From: Michael Eastham
Sent: 01 February 2018 11:49
To: 'Graham, Laura'
Cc: Planning.Responses
Subject: RE: LU/121/17/RES

I hereby approve the proposed substitution of the Sutherland Blend brick, produced by Edenhall, with the Beaufort Blend brick, which is also manufactured by Edenhall, as shown on drawing 543-PL-SITE LAYOUT - 107 rev F.

The Beaufort Blend brick will be used in Phase 2 (LU/121/17/RES) at North Littlehampton Strategic Development Area .

Hard Landscape LA107

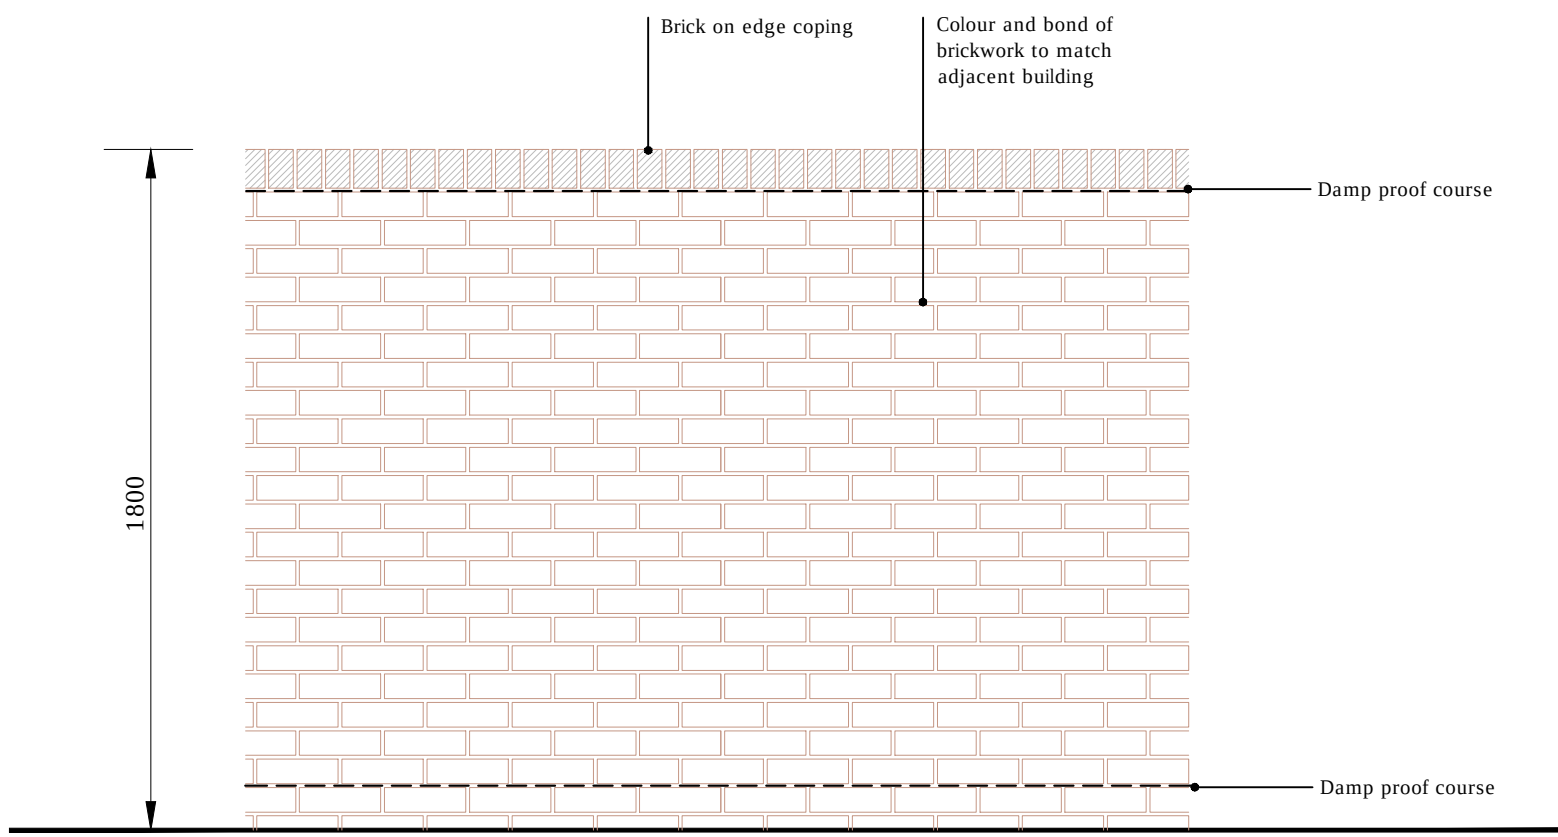
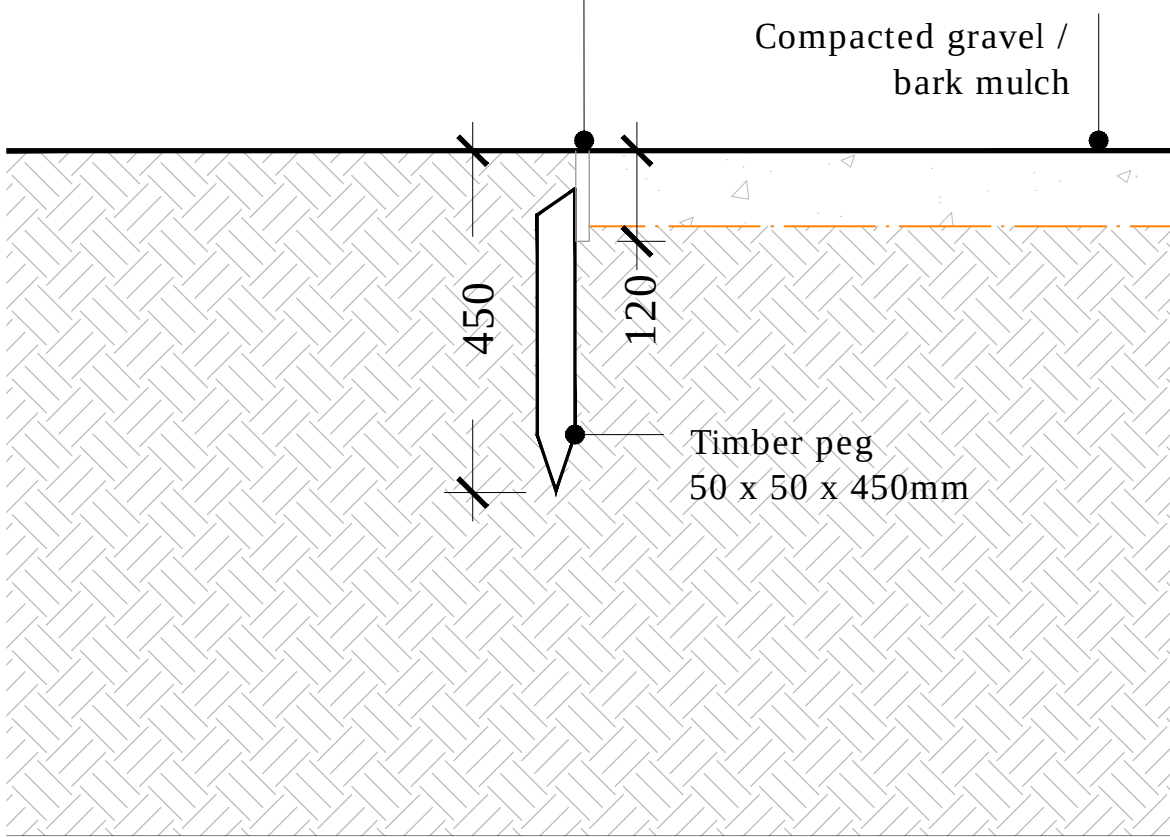
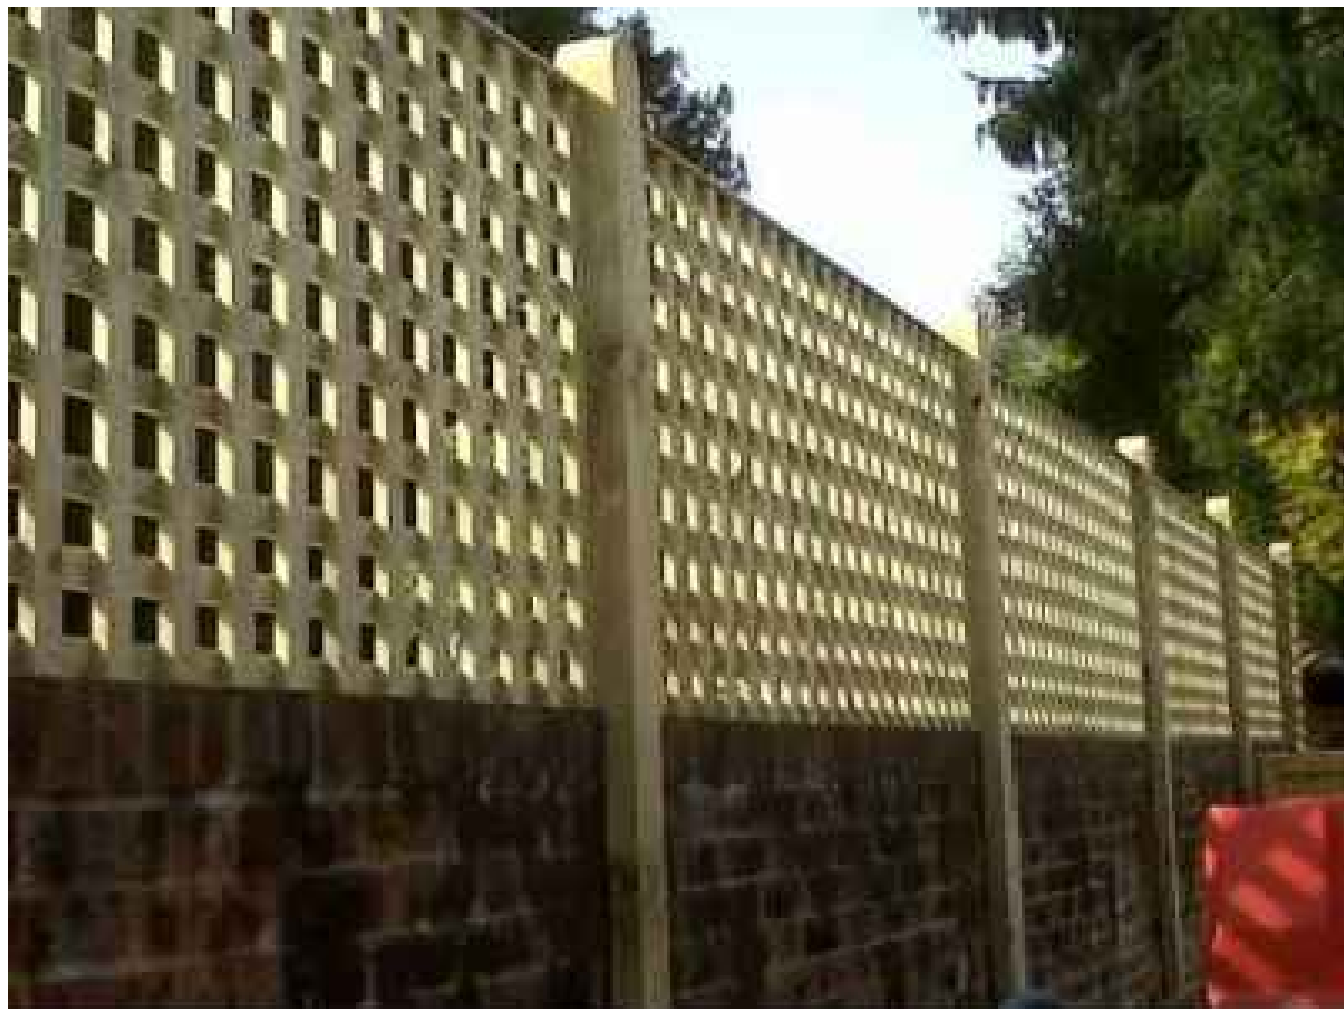
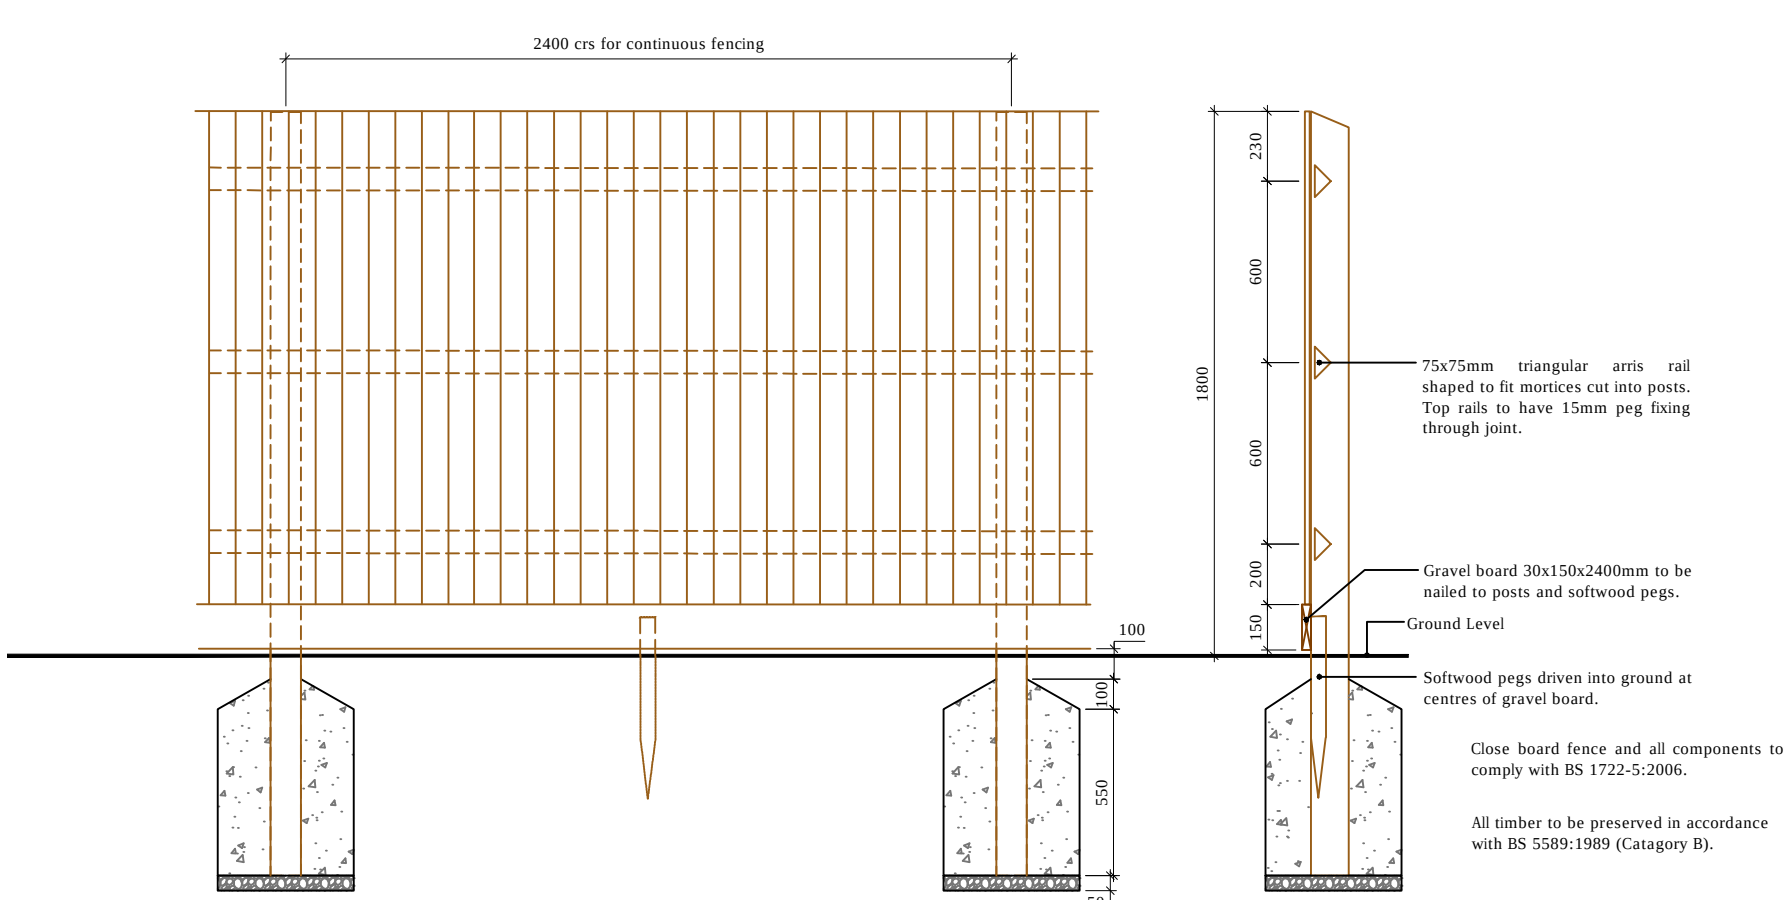
I have just been informed that one of the approved bricks for LU/121/17/RES is no longer available - namely the Sutherland Blend by Edenhall (its production has been discontinued - which is very annoying).

The proposed substitution is Beaufort Blend, also by Edenhall. It is extremely similar to the Sutherland Blend in that it is a pale brick with pink and grey hues, so I am hoping you can agree to the substitution.
